Your Ref: OWPC15638
Our Ref: WA/57/17/PL 04-08-2017
Please ask for:
Mrs A Gardner

Conversion of 2 No. flats into 1 No. dwelling with two storey front & rear extension
(resubmission following WA/25/16/PL).

1 & 2 Stafford Cottages Yapton Lane Walberton

| PROPOSED FLOOR PLANS, ELEVATIONS, ROOF PLAN & BLOCK                                               |                      |    |          |

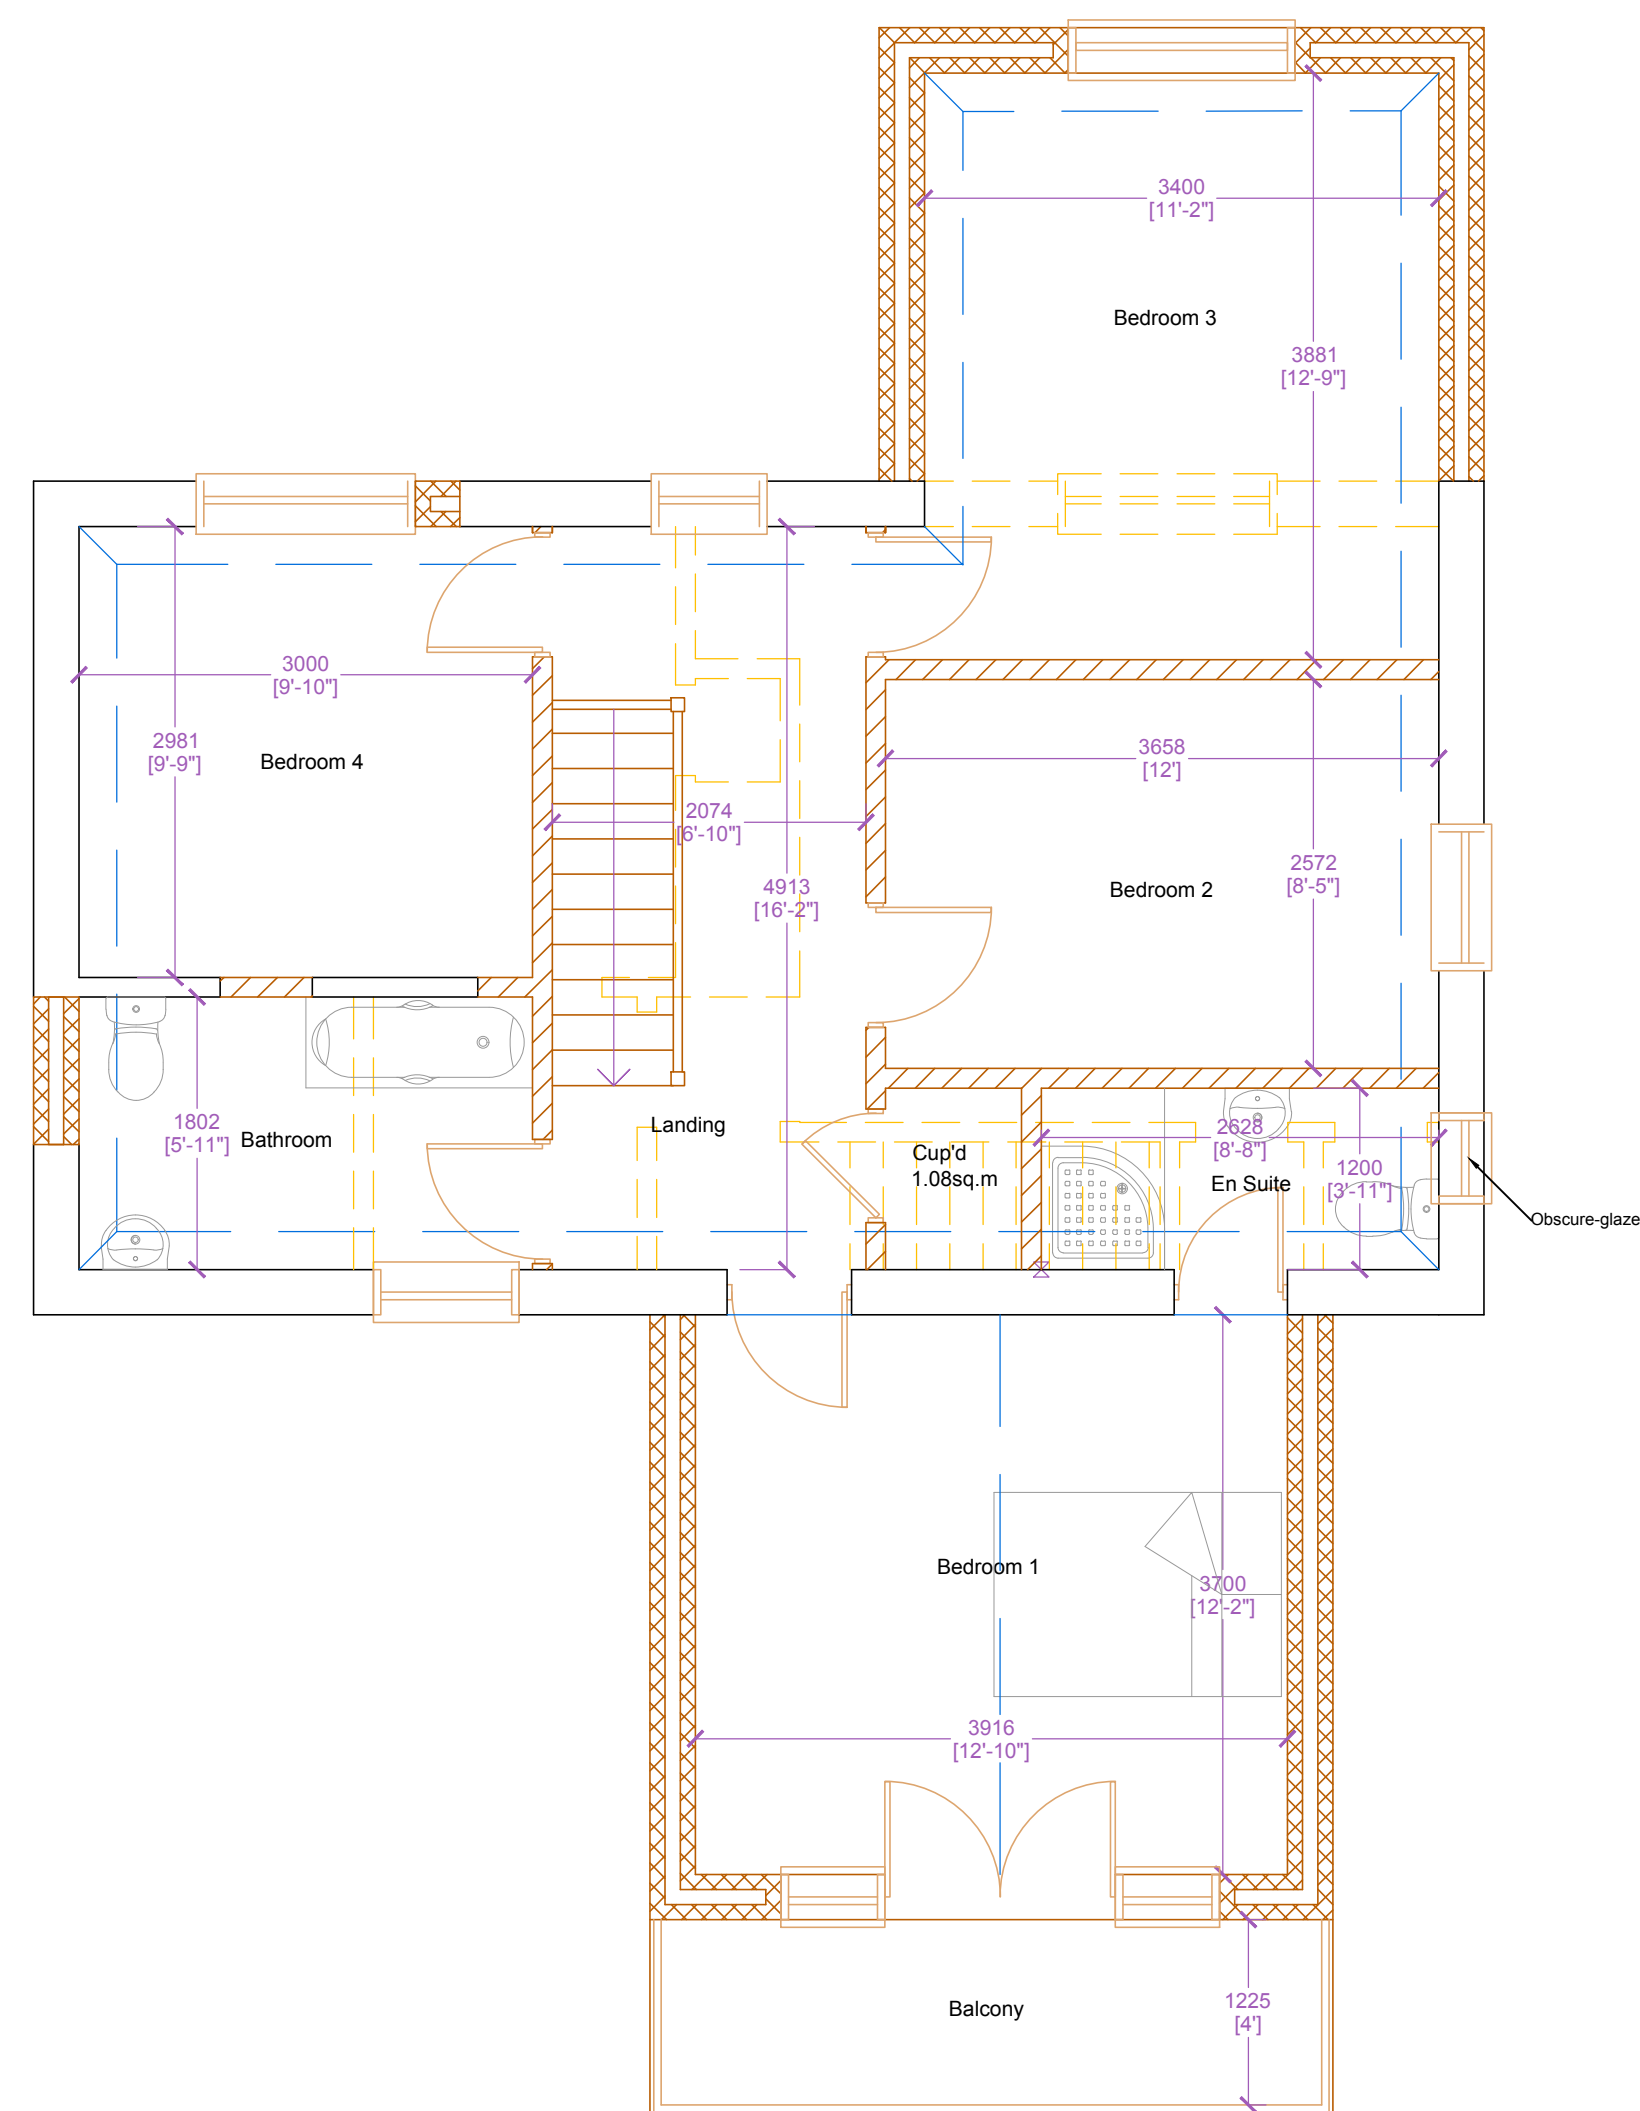
This application relates back to WA/25/16/PL. In the drawings submitted with this, our privacy was initially protected by the balcony being fully inset within the first floor walls (drawing 15200/02R4 dated 6/5/16). This drawing was replaced by 15200/02R6 and 15200/02R7 (both dated 6/7/16) in which the walls were removed and neighbours' privacy was protected, to a lesser extent, by a floor-to-ceiling, obscured glass screen which extended to the extreme edge of the western wall. The drawings show the balcony as being a uniformly flat surface with the screens and a western balustrade fixed to the floor.

What has actually been built is a low wall around the balcony, not shown in any of the drawings in WA/25/16/PL or WA/57/17/PL. Attached to this wall is a staircase-style, pipework banister/balustrade with glass panels held in place by long clips. The horizontal rail on the western elevation is carried round the corners to continue some way into the northern and southern elevations, before rising diagonally to ceiling height. The effect of this is that anyone leaning on the horizontal rail can see clearly into the northern and southern neighbours gardens, right back to their back walls and leaving no area not overlooked. Further, the glass panels have large gaps of several inches surrounding them and the framework itself is set out from the western wall, leaving significant gaps through which neighbours gardens can easily be seen. These are not privacy screens, they are just decorative panels.

This in no way resembles the screening for which approval was given. Just as WA/75/16/DOC sought permission for a cheaper cladding than was originally specified, now WA/57/17/PL seeks permission for a cheaper balcony screening than was originally approved, at the cost of neighbours' privacy. It is easy for people on the balcony to see over and through the balustrade. During the building work, both neighbours experienced workmen calling to them from the balcony.

The design of the screening that has been installed and for which permission is sought does not satisfy either policy quoted in the conditional approval given to WA/25/16/PL. It DOES have an adverse overlooking effect on neighbouring properties, in that all their gardens, from house to western hedge, can be stared into from the balcony. This contravenes policy DEV19. This forms an unacceptable adverse impact on the neighbours in that it severely compromises their ability to enjoy their gardens undisturbed and unobserved, in contravention of GEN7. We are entitled to have our private life and home respected and this application should be refused as it infringes both this right and local policies.
